Our ref: AN/2026/137555/01-L01
Your ref: H14-0132-26
Date: 05 March 2026

**Erection of 3 bed self-build dwelling, domestic workshop and garage
Adj 4 Clay Drove Pode Hole**

Environment Agency position

Job Title Proposed 1no. Self Build Plot 4 Clay Drive, West Pinchbeck PE11 3NB For: Mr Smith	Date Jan 2026	Drawn by AL Checked by
Drawing Title Planning Drawing Floor Plans & Elevations & Section	Job No. SE-2444 Dwg No. PP1100	Sheet Size A1 Revision

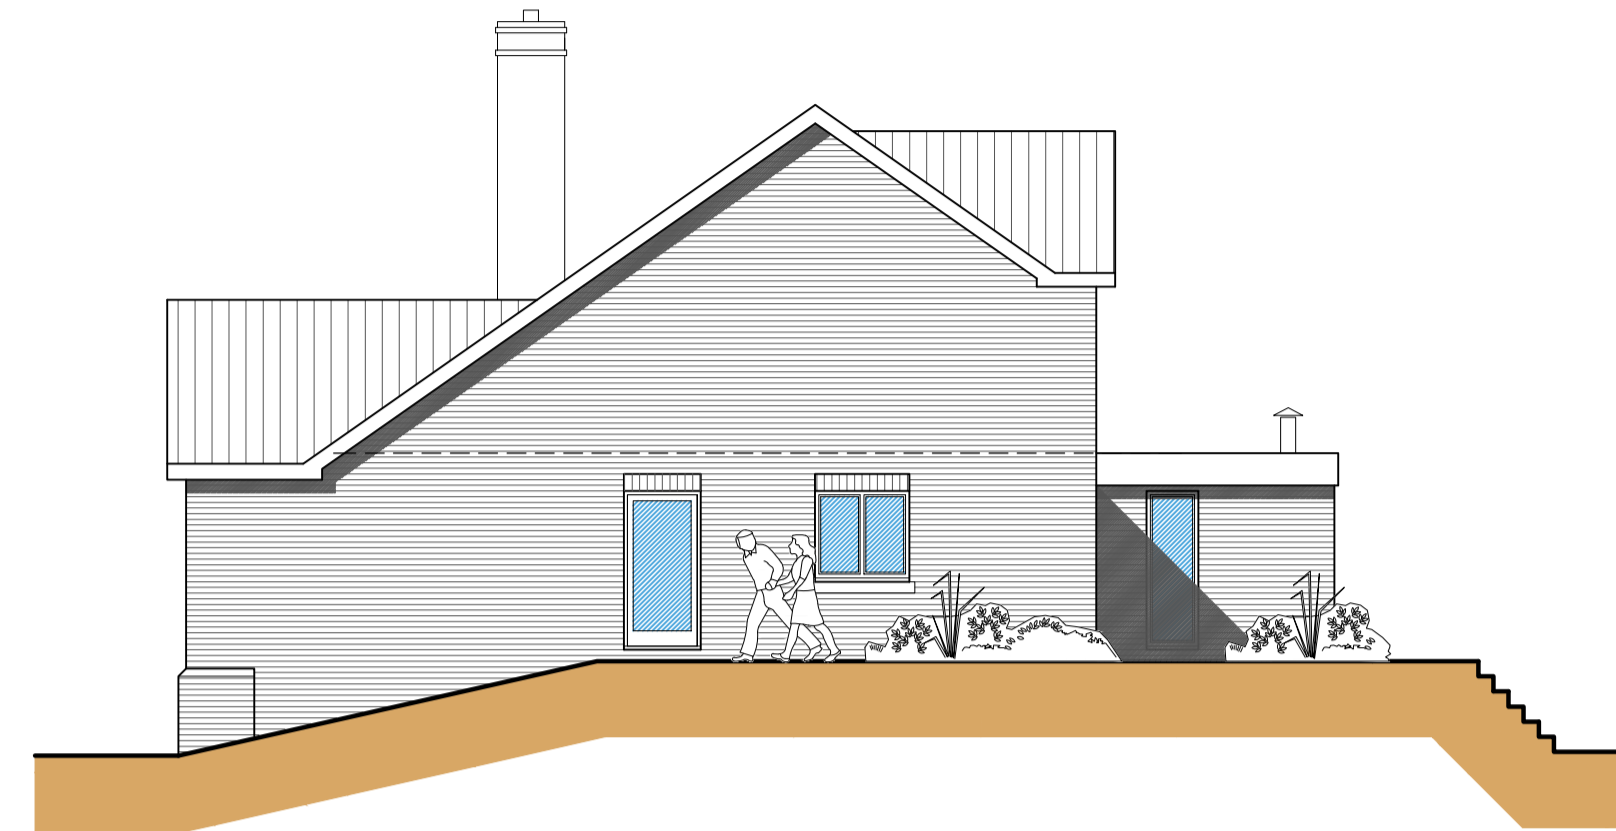
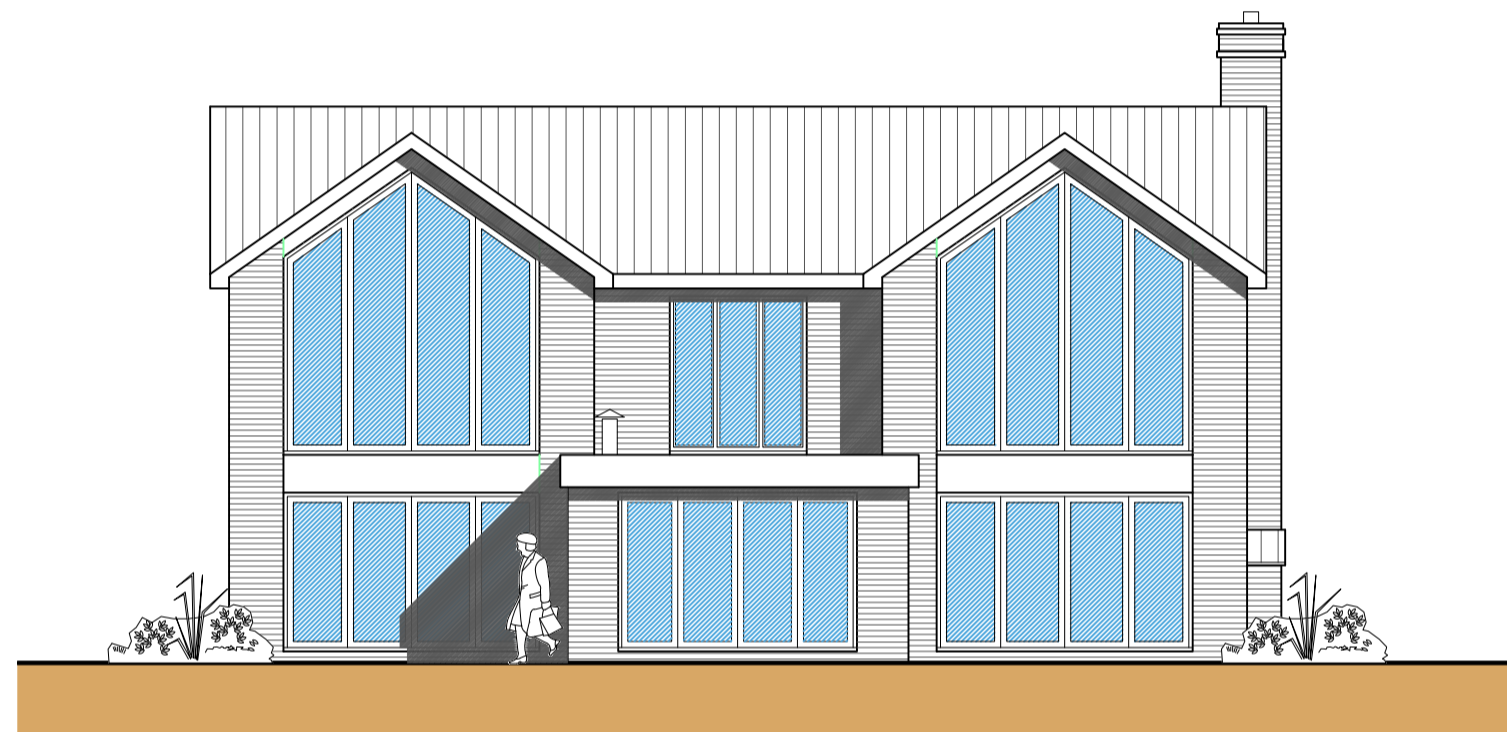
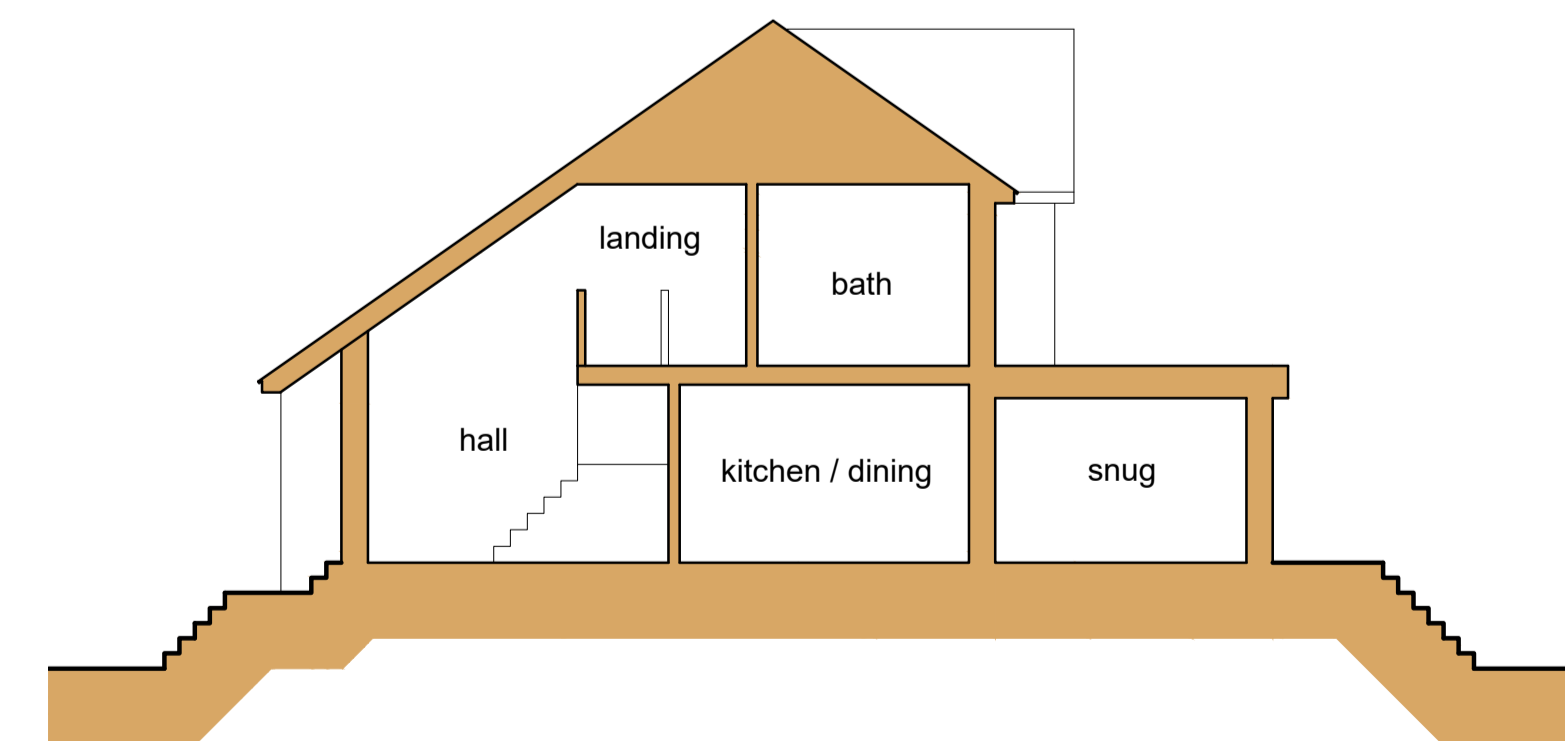
- The finished floor level of the dwelling shall be set no lower than 1.0m above existing ground level, equivalent to 2.9 metres above Ordnance Datum AOD
- Flood resilient construction shall be incorporated to 0.6m above the finished floor level
- The dwelling shall have a minimum of 2 storeys
- Demountable defences shall be incorporated to a height of 0.6m above the finished floor level
